Recommendation Report for Planning Permission for Works or Extension to a Dwelling

REF NO: EP/93/14/HH

LOCATION: 12 Tamarisk Way
East Preston

PROPOSAL: Remodelling of house comprising of the removal of existing pitched roof & introduction of flat roofs together with extensions & alterations

DRAWING: SITE PLANS, PROPOSED FRONT & SIDE ELEVATIONS & PROPOSED GROUND FLOOR PLAN
SCALE: 1:1250 1:500 1:100 1:50
DRG No. 1030/3 **DATE:** MARCH 2014

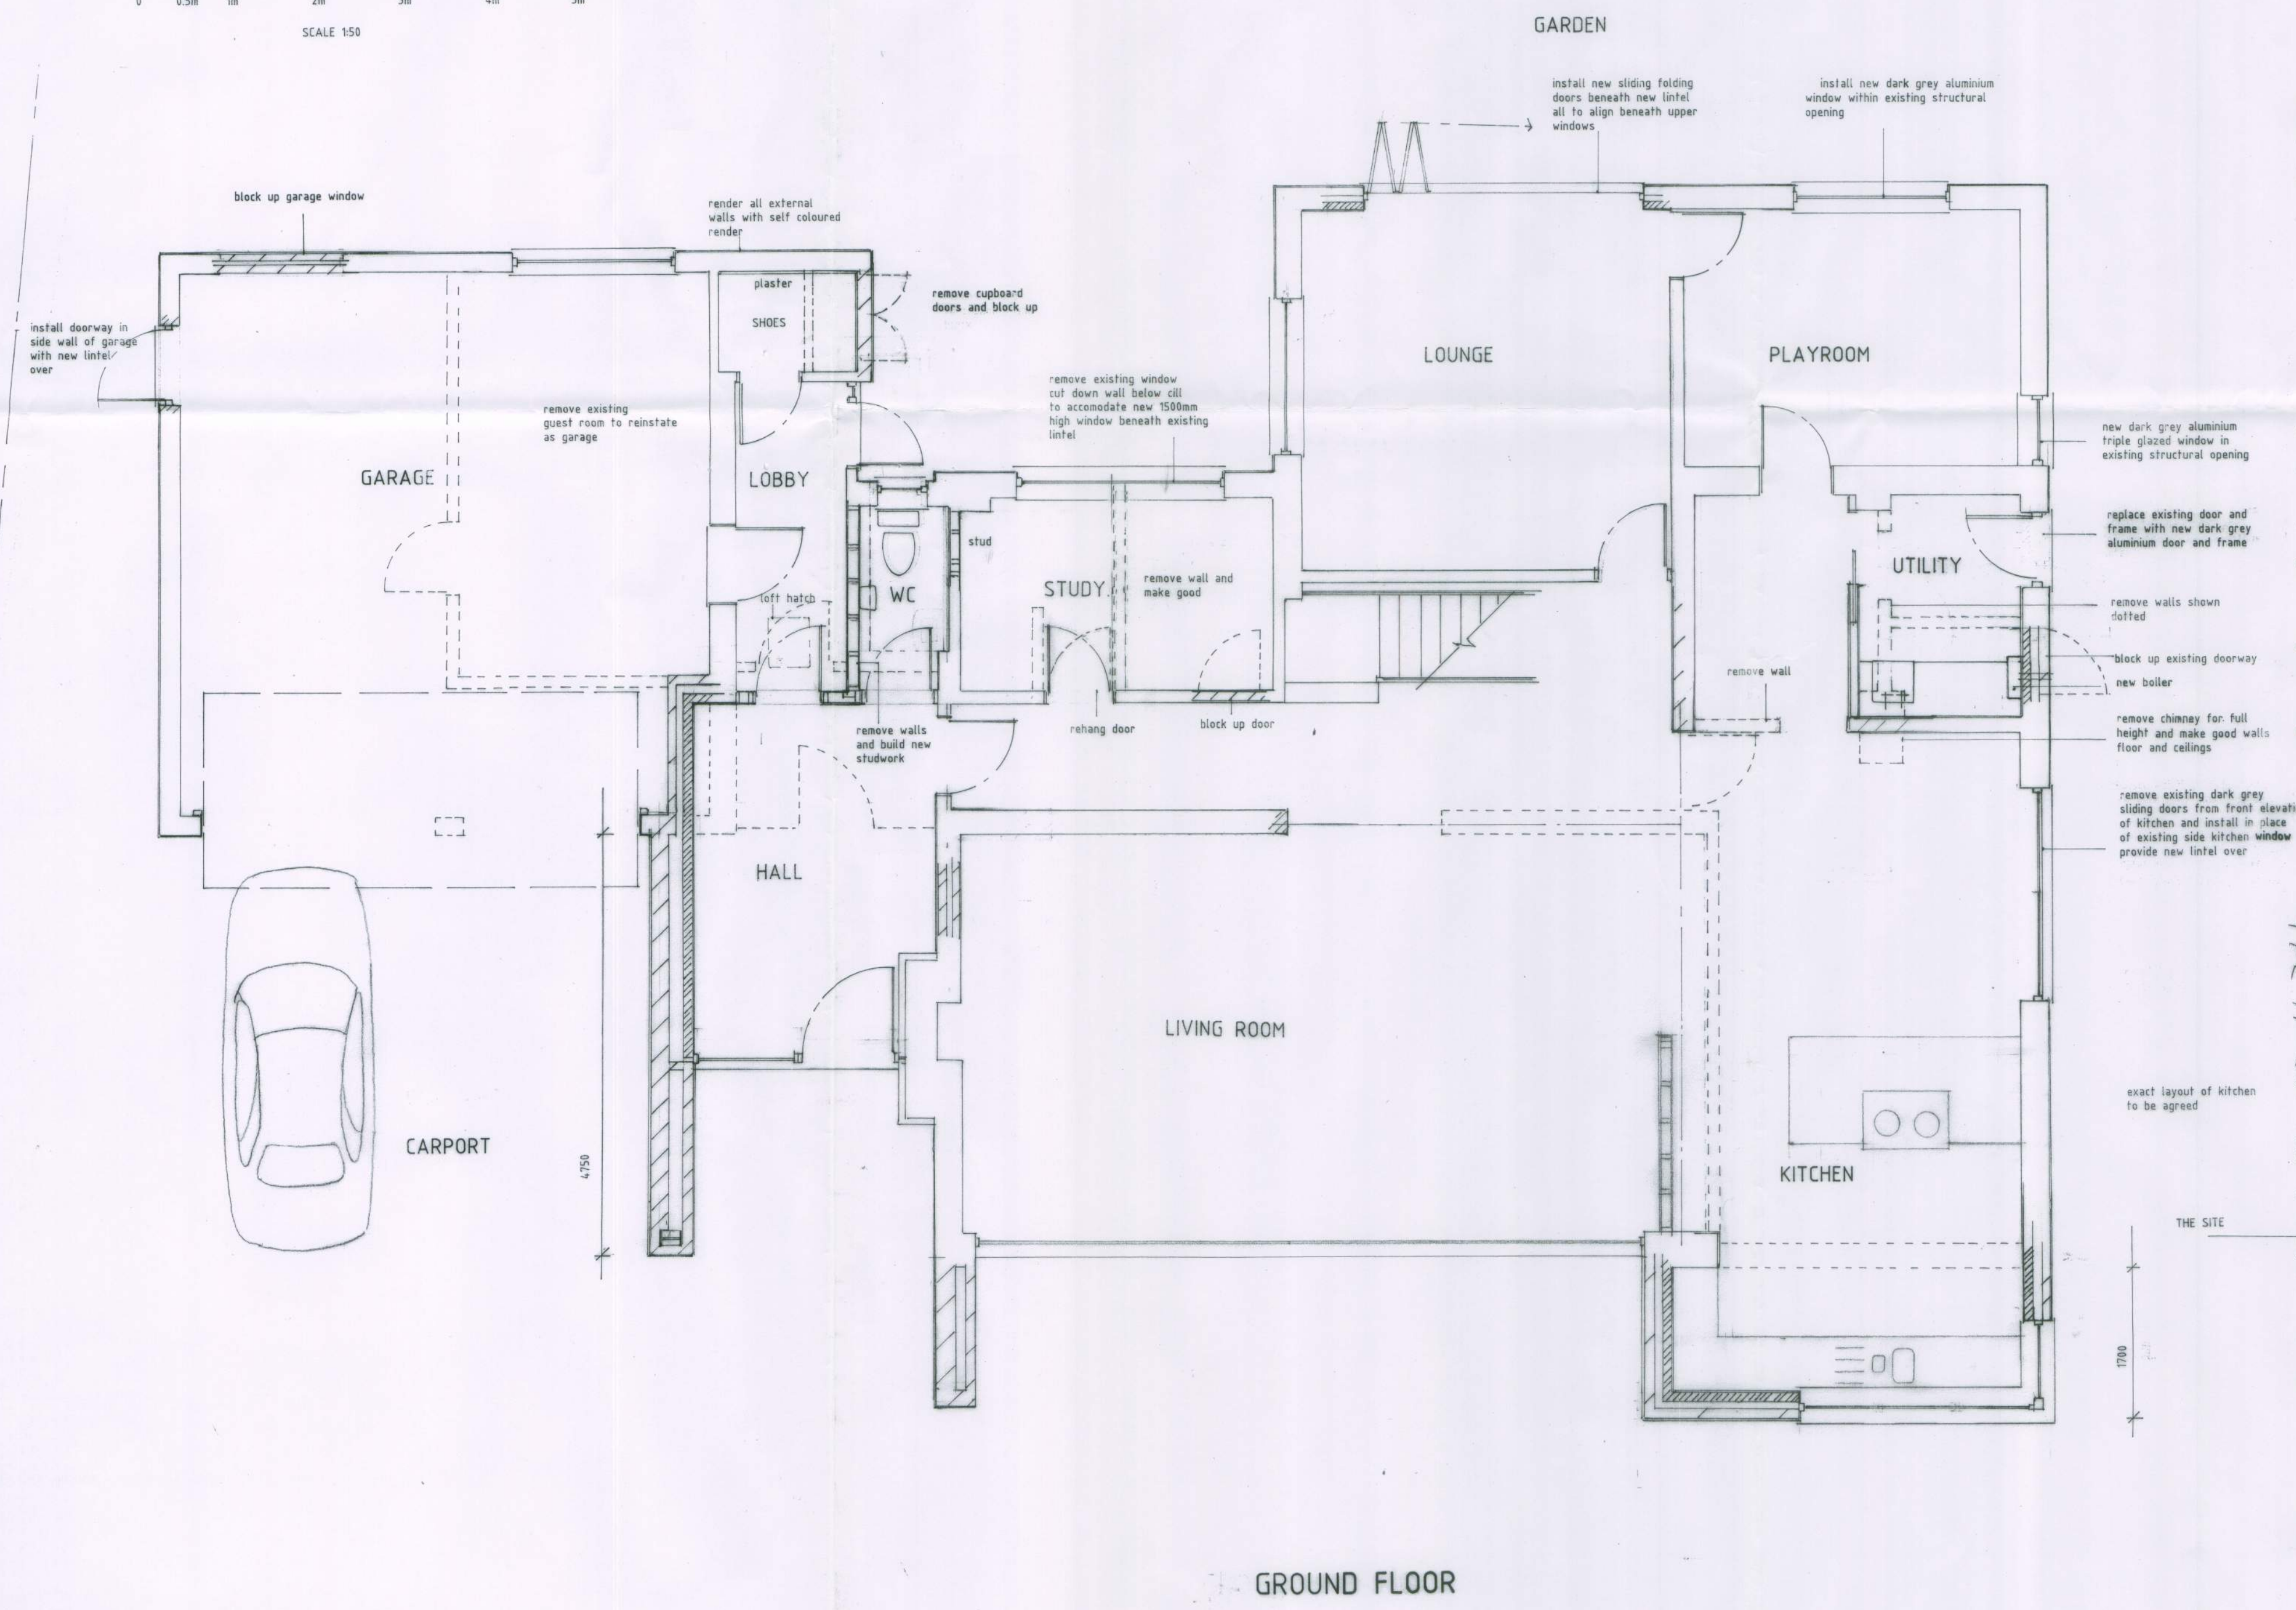
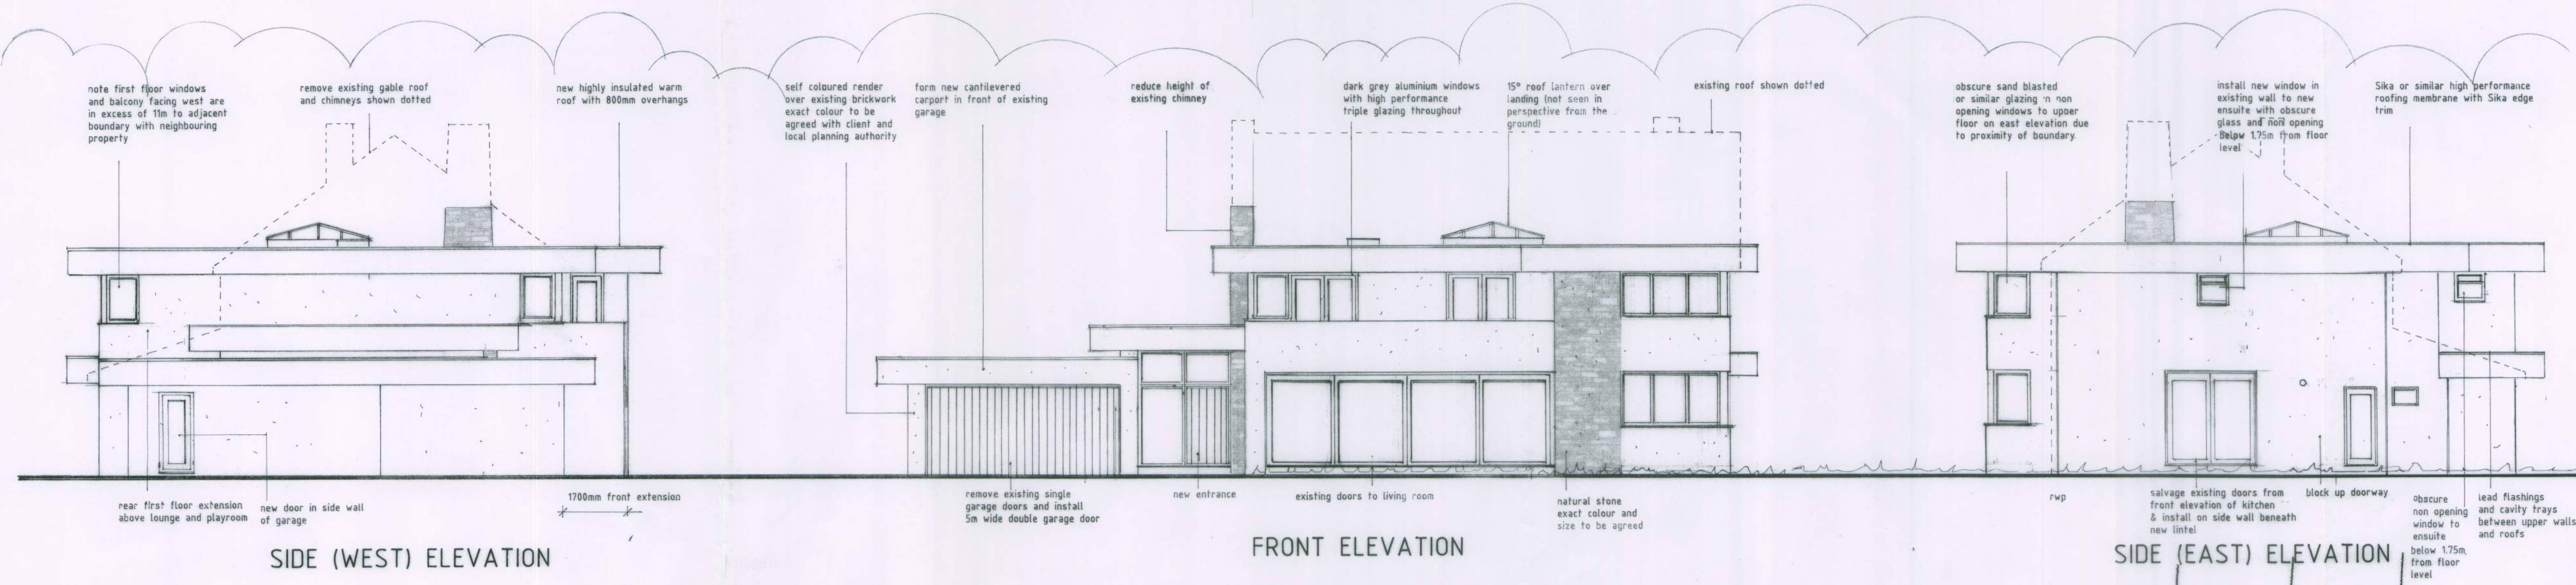
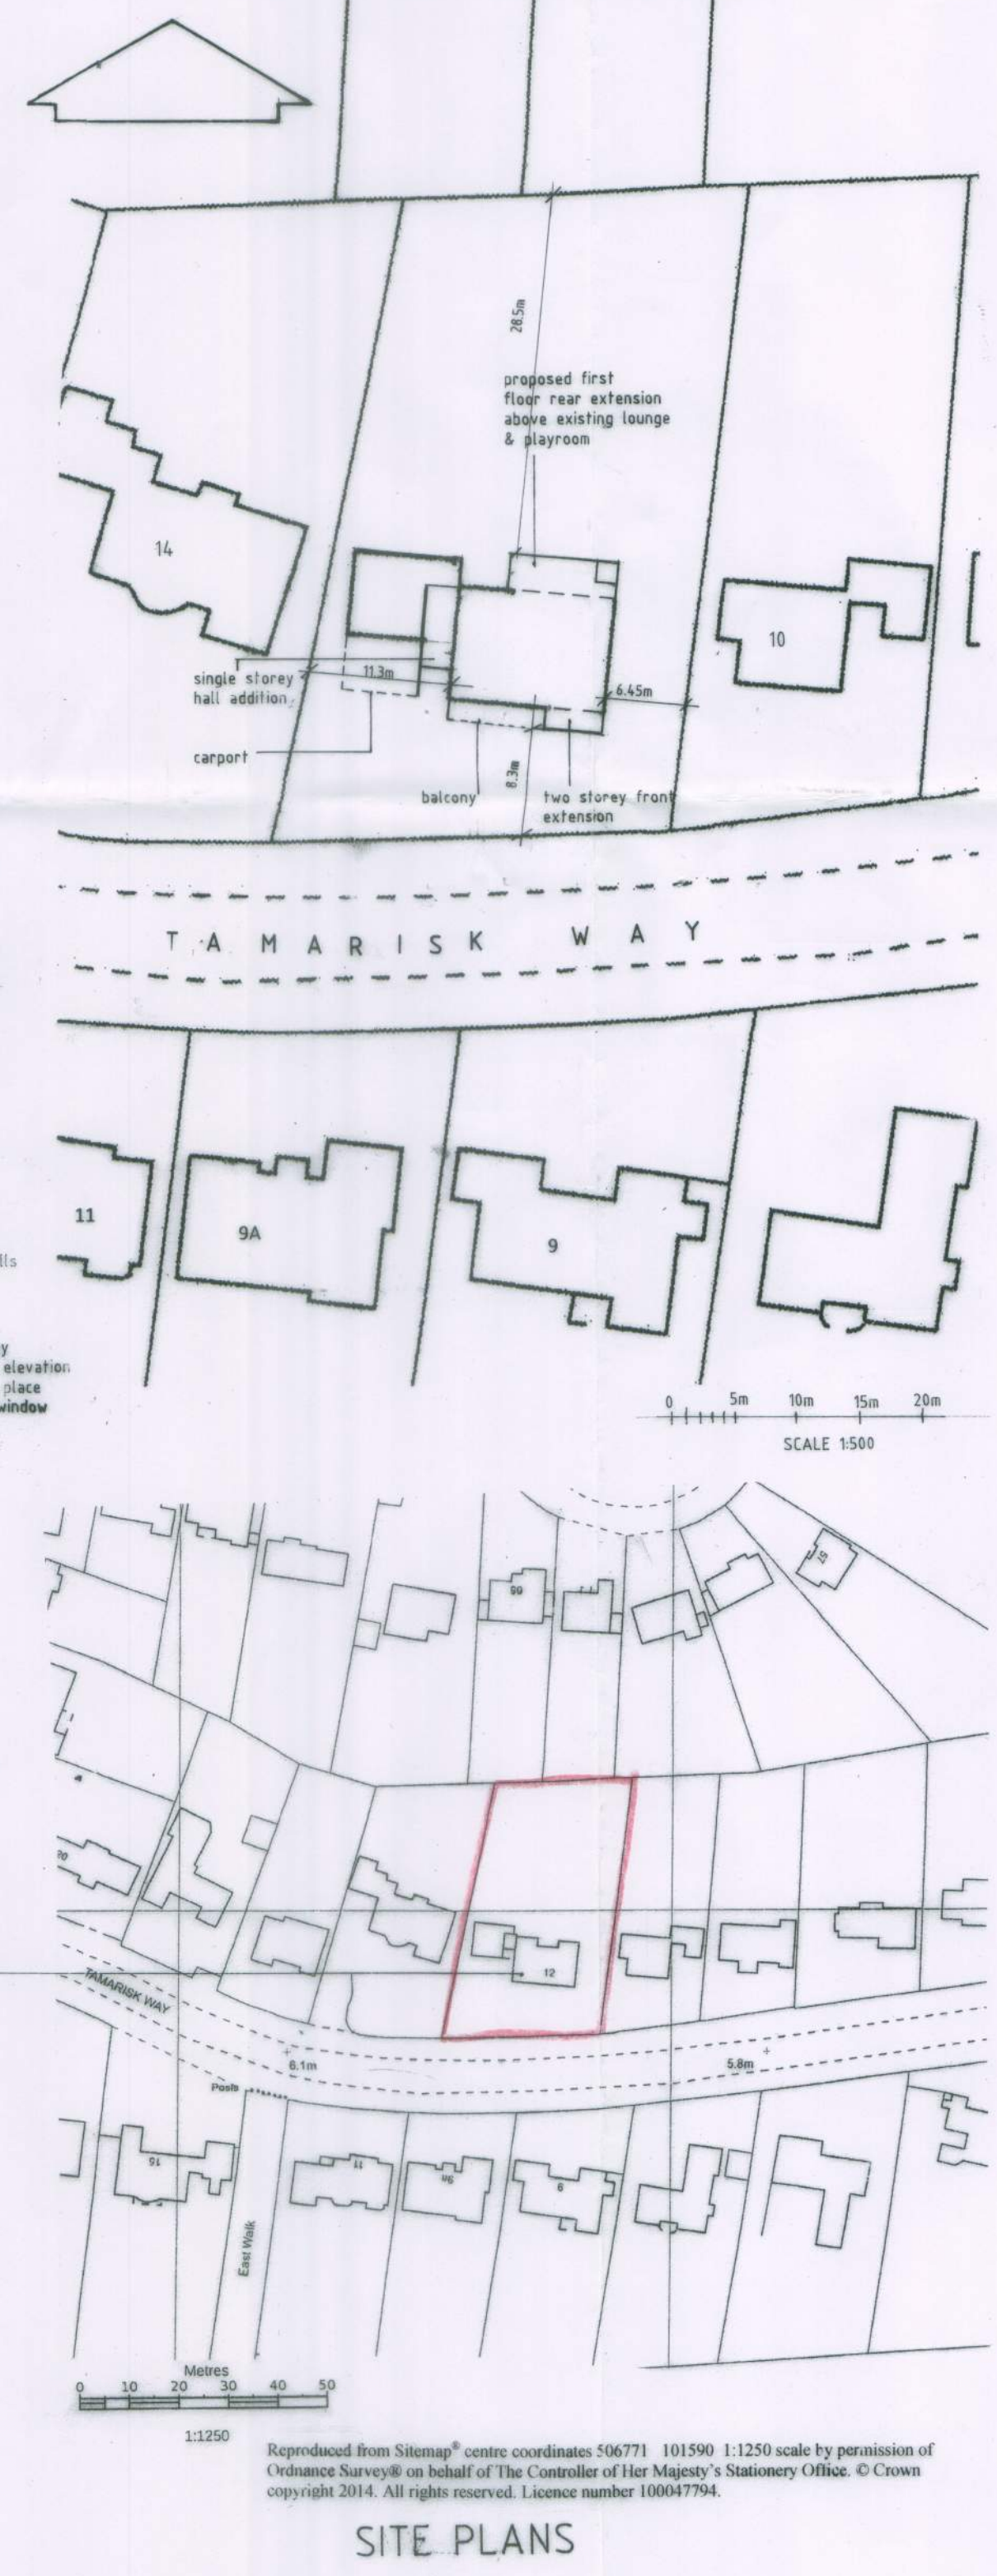
This application seeks planning permission for various extensions and alterations to the existing two storey detached property. The cumulative effect of these additions would be to substantially change its appearance from a traditionally designed property with white painted brick and PVCu clad elevations with a pitched tiled roof to that of a more contemporary angular form of development with a flat roof and render and natural stone elevations.

Whilst the plot is significantly sized and is considered to comfortably accommodate the scale and type of the proposed extensions and alterations, it is in the resultant angular design that each combines to form a significant departure from the spirit of the original dwelling.

with pitched and hipped tiled roofs, in particular at Nos. 10 and 14 either side of the property and on the opposite side of the road at Nos. 7, 9, 9a and 11. In fact, the proposed form of development particularly with the introduction of a flat roof is not seen anywhere else in this section of Tamarisk Way and as such is considered to be harmfully out of character with its surroundings.

Whilst other properties are set comfortably back from the road and separated by wide grass verges and long drives, this property is in closer proximity than most and coupled with its position on a small bend in Tamarisk Way is particularly noticeable in the street scene, especially when viewed from west to east. The combination of this prominent position and the stark, alien design of development created by the extensions and alterations even though it has a lower roof height than existing would lead to a harmful appearance in the street scene and the surrounding area.

- 1 The proposed extensions and alterations to the property which is prominently placed in Tamarisk Way would combine to substantially alter its appearance into an angular form of development with a flat roof that is considered to be harmfully out of character with the more traditionally designed neighbouring properties with hipped and pitched tiled roofs and so would appear harmfully out of character with its surroundings and the wider area in conflict with policies DEV19(i)&(iv) & GEN7(ii) of the Arun District Local Plan.
